United Wambo Open Cut Coal Project and Hunter Valley Operations Modification 5

- “United Wambo Open Cut Coal Mine Project and Hunter Valley Operations Modification 5 – Cumulative Air Quality Impact Assessment Peer Review”. Letter from Ramboll to the DP&E, dated 1 November 2017.

This letter has been jointly prepared by Jacobs (consultant to Glencore for the United Wambo project) and Todoroski Air Sciences (consultant to Yancoal for the HVO project). Its purpose is provide the information requested by Ramboll.

Figure 3 Summary of predicted annual average PM₁₀ impacts

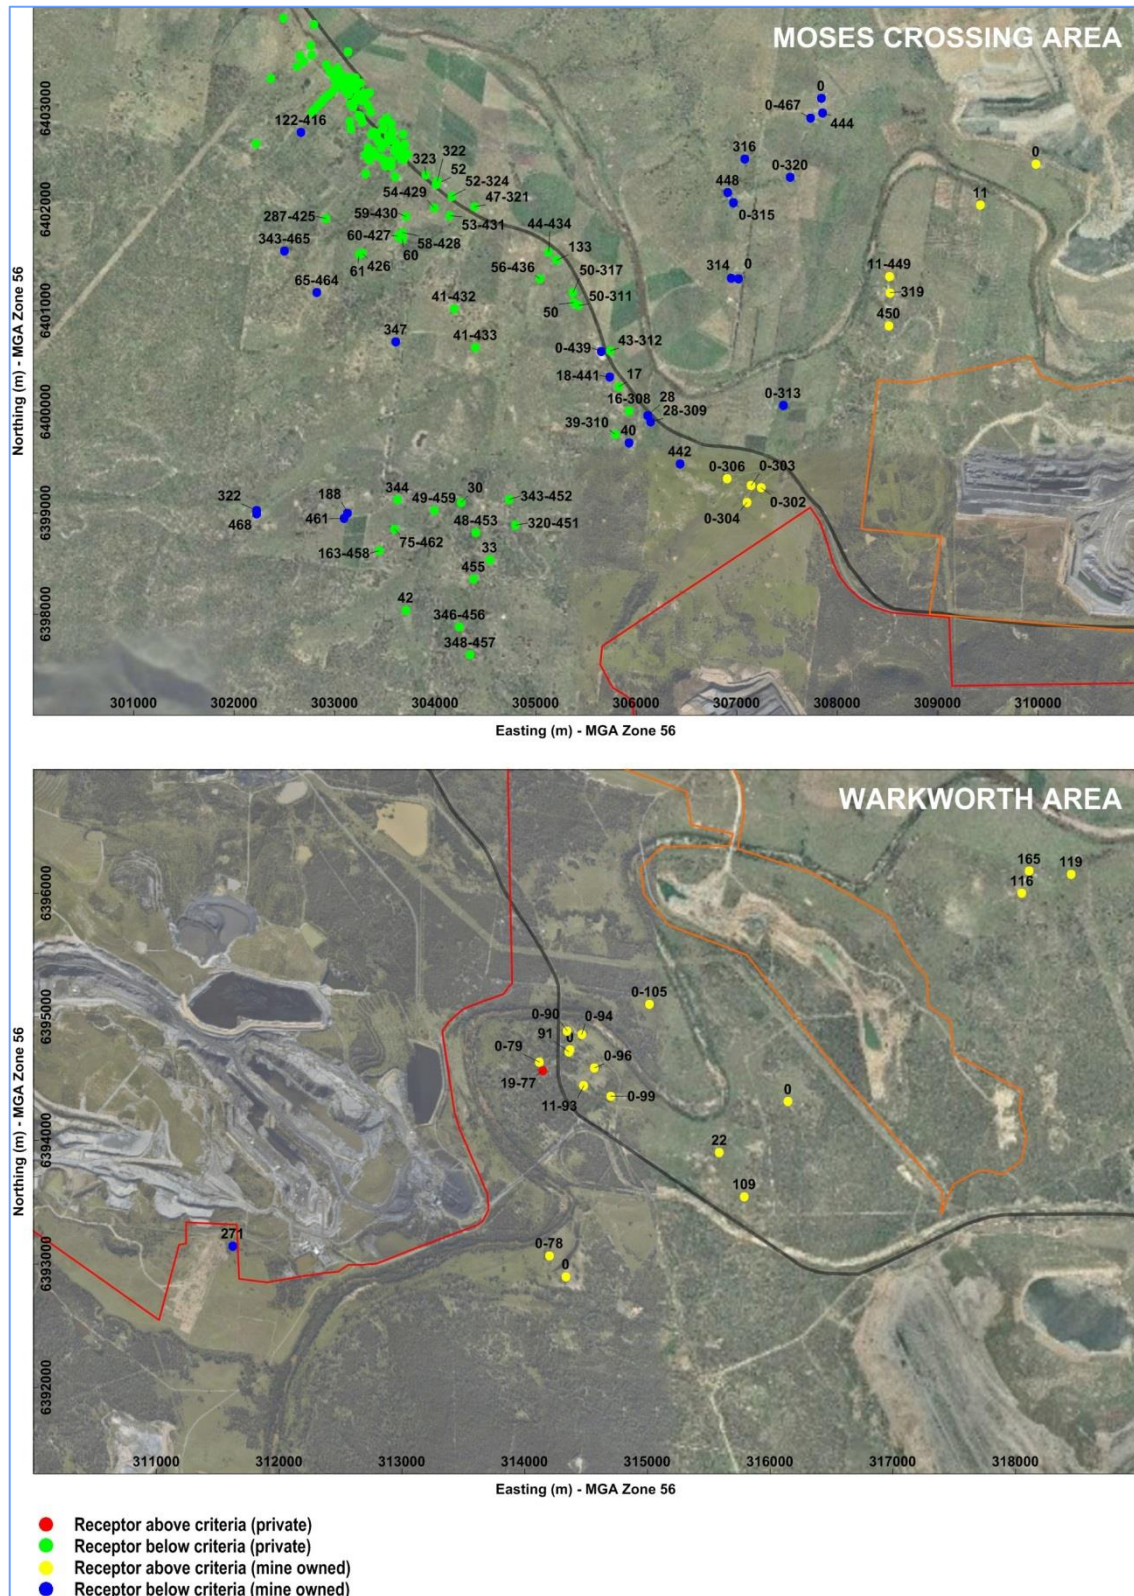
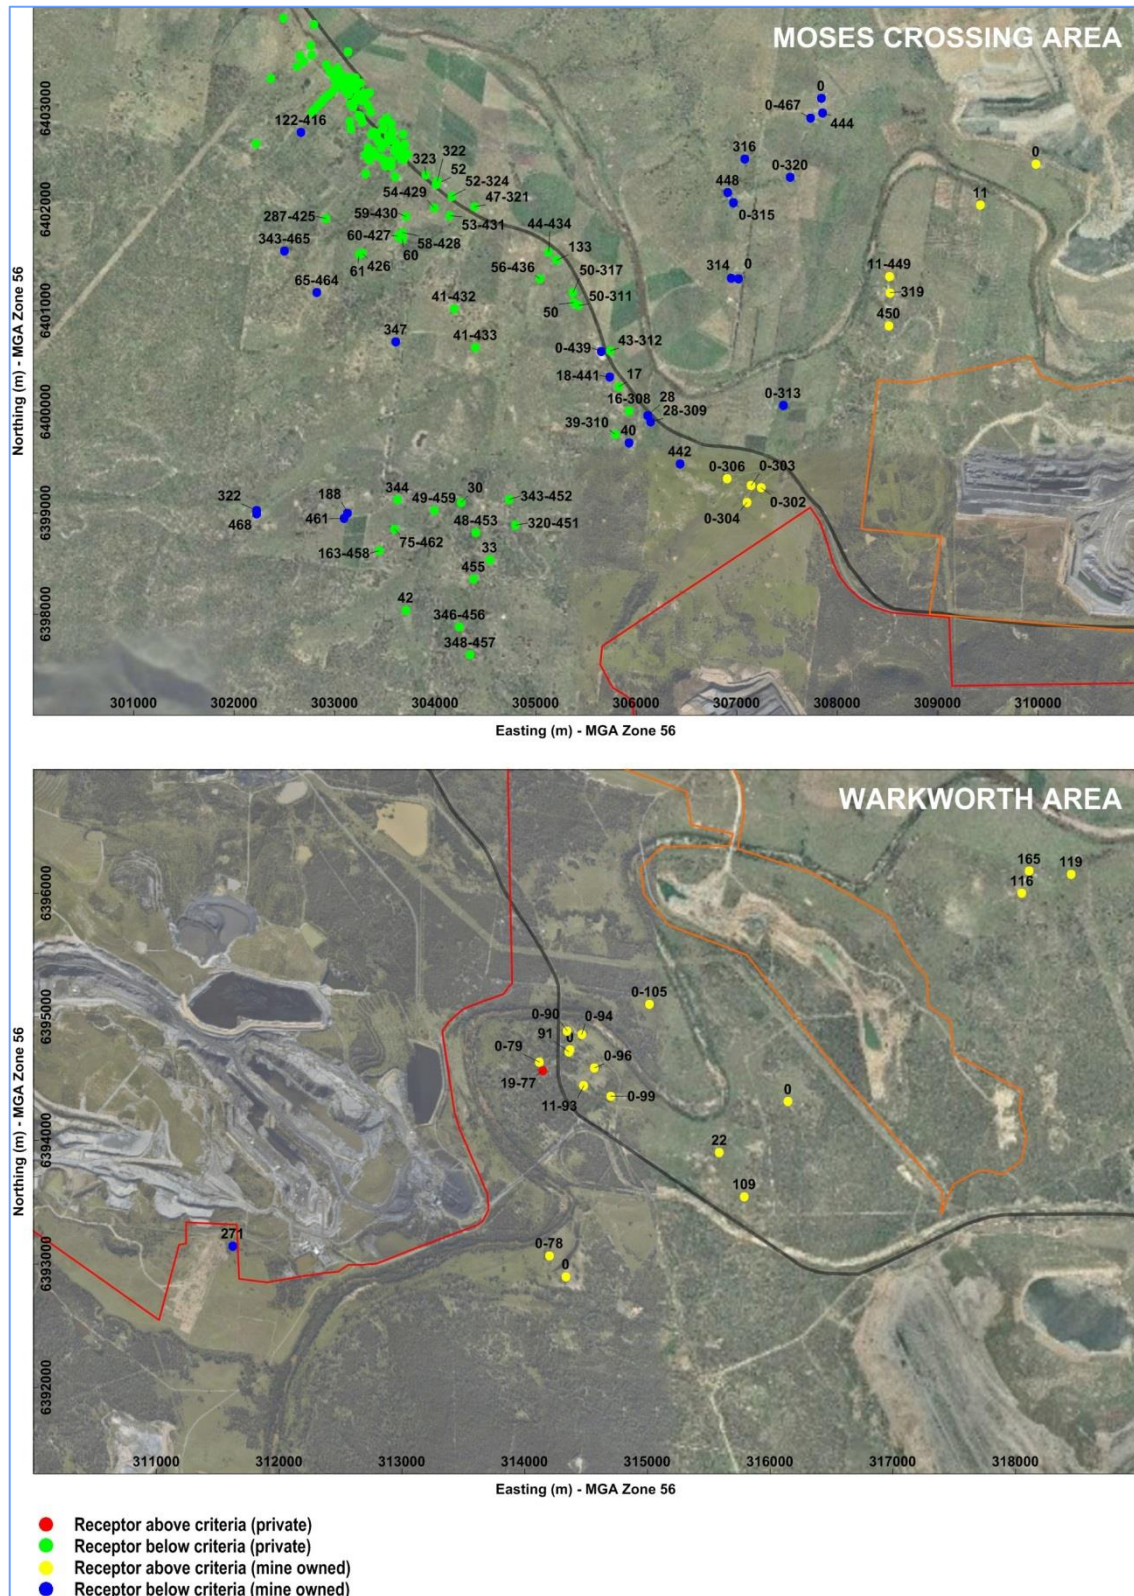
However, it is considered that more robust justification for the selected the annual PM_{2.5} background is provided Jacobs/TAS.

The average relationship between concurrent PM₁₀ and PM_{2.5} concentrations recorded by the Camberwell OEH monitoring station for 2014 was 0.36. If this ratio is applied to the calculated average PM₁₀ concentration (19.5 µg/m³), the corresponding PM_{2.5} concentration is 6.9 µg/m³.

Using this derived PM_{2.5} background from the measured PM₁₀ concentrations, it is considered that the approach adopted for deriving non-modelled PM₁₀ is applied for annual PM_{2.5}. Specifically, the predicted annual average PM_{2.5} concentrations at the PM₁₀ monitoring locations should be averaged and then subtracted from the annual averaged PM_{2.5} background of 6.9 µg/m³ (similar to Table 3 of the joint cumulative assessment).

The cumulative annual average PM_{2.5} concentrations at each receptor should then be recalculated for this revised non-modelled annual average PM_{2.5}.

As noted in the joint cumulative assessment (18/9/17) there are no locally available PM_{2.5} data in the area of interest that are representative of the nearest receptor locations. Therefore, the PM_{2.5} concentration had to be estimated on the basis of other data.

Data from Singleton and Muswellbrook were ruled out as these monitoring sites are located in towns, with little in common to the study area in terms of their air shed emission sources. The Camberwell Village monitoring site was identified as the site located in an area most similar to the study area. However, it was also noted that the Camberwell Village monitoring site is located near a heavily trafficked highway (i.e. the New England Highway) and in an area where there is likely to be more anthropogenic emissions due to activity in the village. These factors mean that the Camberwell monitoring site will most likely measure higher PM_{2.5} concentrations relative to the study area. For reasons including these, using the Camberwell data is not considered to robustly represent the locations of interest.

But in any case, using the 0.36 PM_{2.5}/PM₁₀ ratio from Camberwell to derive a PM_{2.5} level of 6.9µg/m³, as suggested by the review, results in a local PM_{2.5} background level of 5.85 µg/m³ after considering the existing project sources that contribute to the local PM_{2.5} levels (i.e. to prevent double counting). Alternatively, taking the PM_{2.5} level to be 0.36 of the local PM₁₀ background level of 12.9 µg/m³ (19.5µg/m³ less 6.6 µg/m³ to prevent double counting), results in a local PM_{2.5} background level of 4.64µg/m³ for this area. Either way, as a higher level of 6.0 µg/m³ was used in the joint cumulative assessment, and the cumulative results meet criteria, there is no clear reason to issue lower revised results in this case.

Figure 5 Predicted cumulative annual average PM_{10} concentrations due to the proposed projects, other mines and background levels

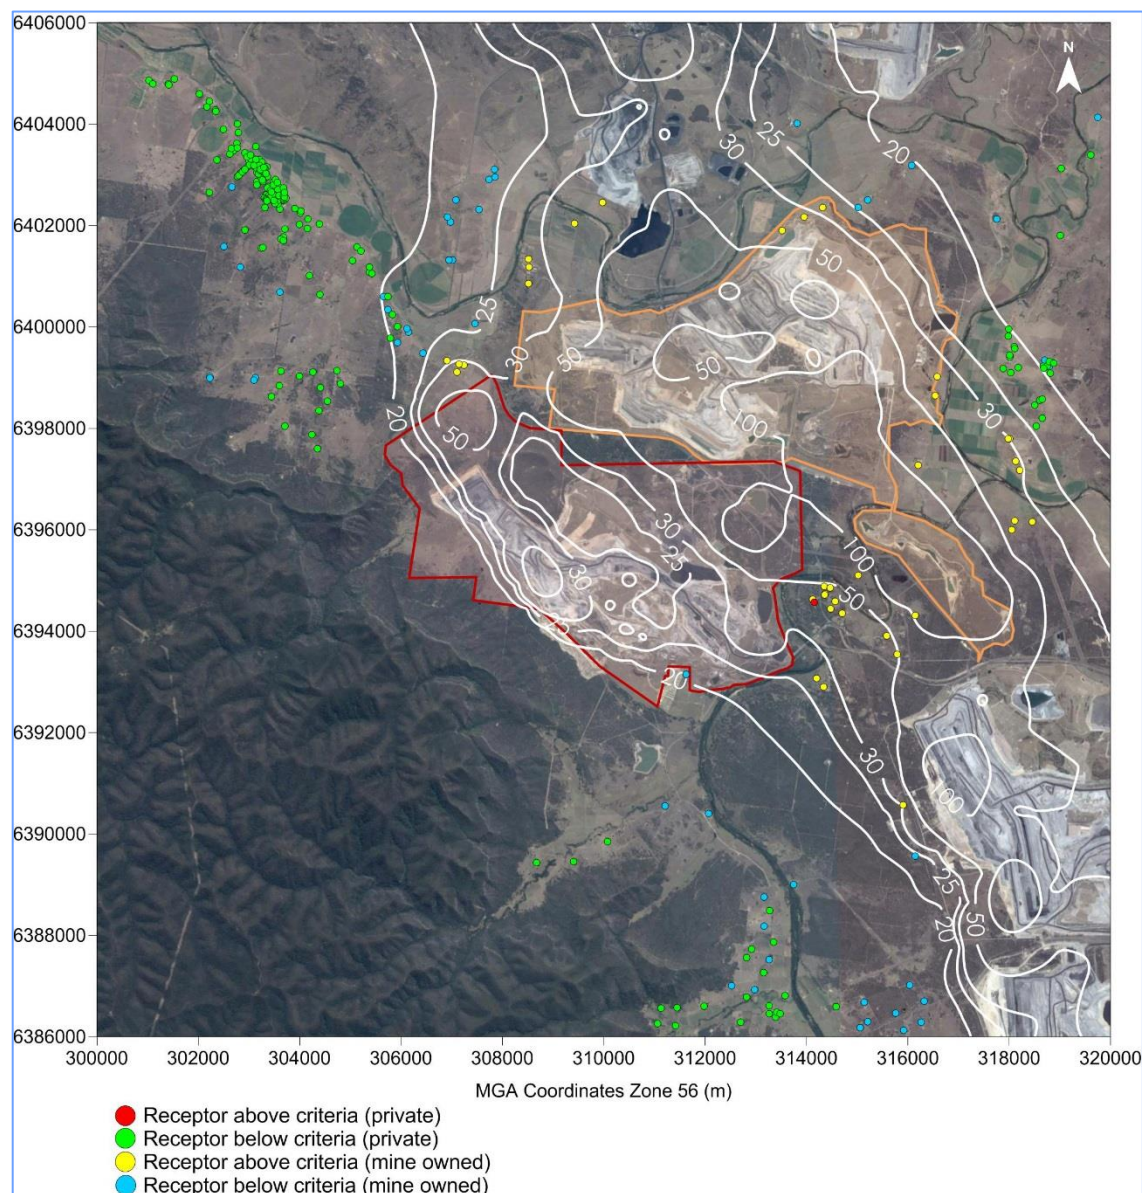
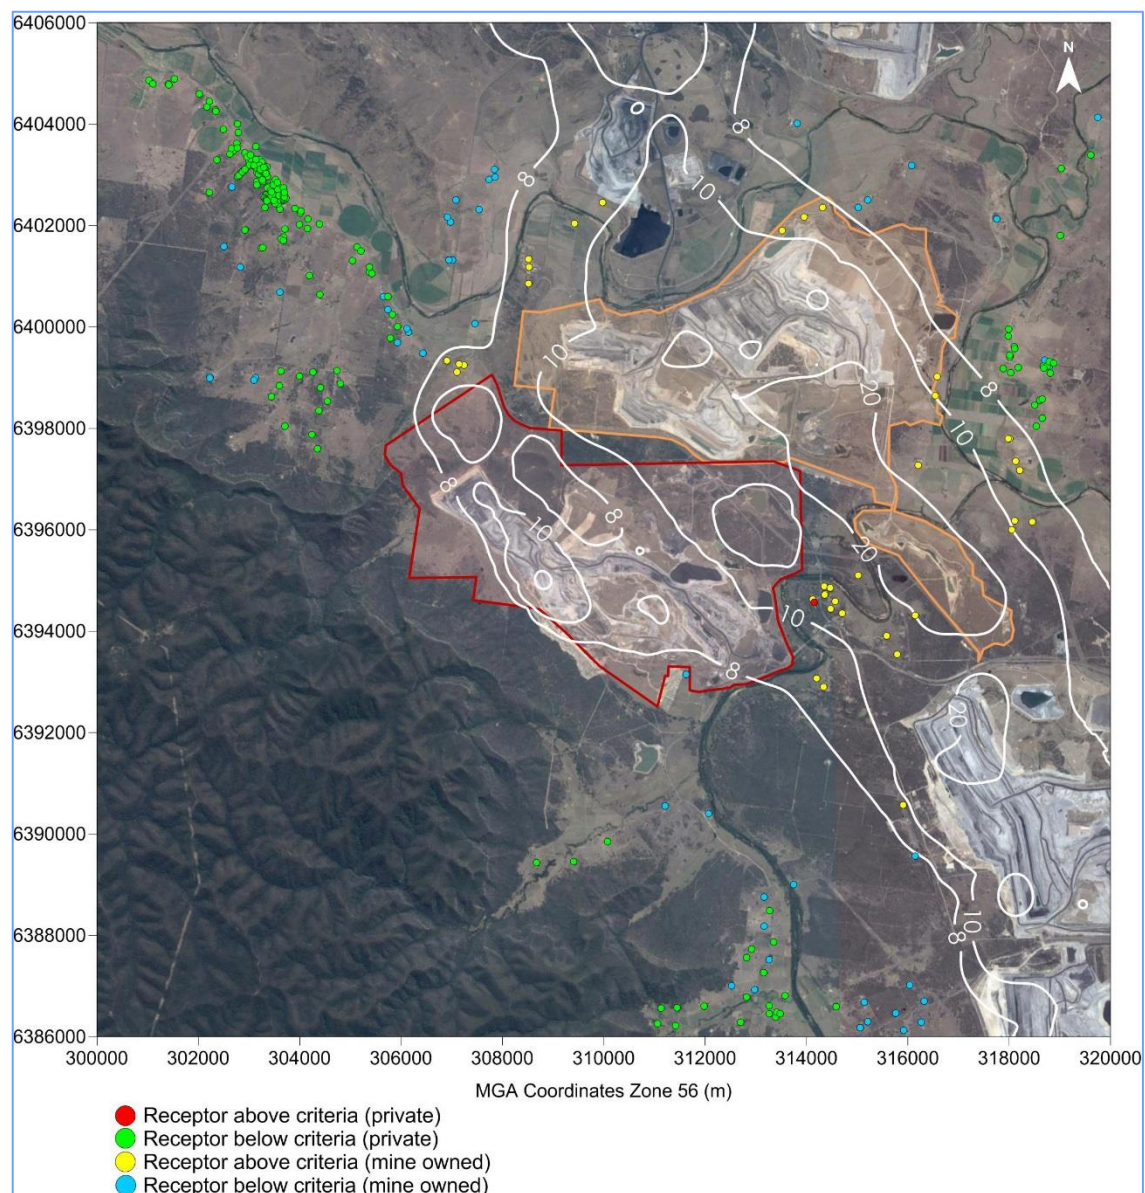
To better illustrate the potential impacts from the UWOC and HVOS in isolation and combination, the 24-hour average PM₁₀ and PM_{2.5} concentrations should be presented and analysed.

At a minimum, the joint cumulative assessment should present project increment 24-hour average PM₁₀ and PM_{2.5} concentrations; specifically:

- UWOC-only increment;
- HVOS-only increment; and
- Combined (UWOC+HVOS) increment.

Because separated dispersion models were run for the UWOC and HVOS mines, combined incremental concentrations will require the collation of timeseries predictions between Jacobs and TAS at each individual receptor location. Incremental results should be presented in a similar fashion to the annual PM₁₀ and PM_{2.5} in the cumulative assessment letter (i.e. tabular format and isopleth plots).

As requested the Project increments of 24-hour average PM₁₀ and PM_{2.5} concentrations have been extracted from the United Wambo and HVO models. For this exercise, the 24-hour averages have been extracted for six locations, representing the nearest privately owned sensitive receptor locations. These locations are:

The results are shown at the end in **Table 1** and **Table 2** for PM₁₀ and PM_{2.5} respectively. As acknowledged by the review, it is not possible to correctly combine maximum short term results from two models, hence short term isopleths for the effect of the two projects combined cannot be presented.
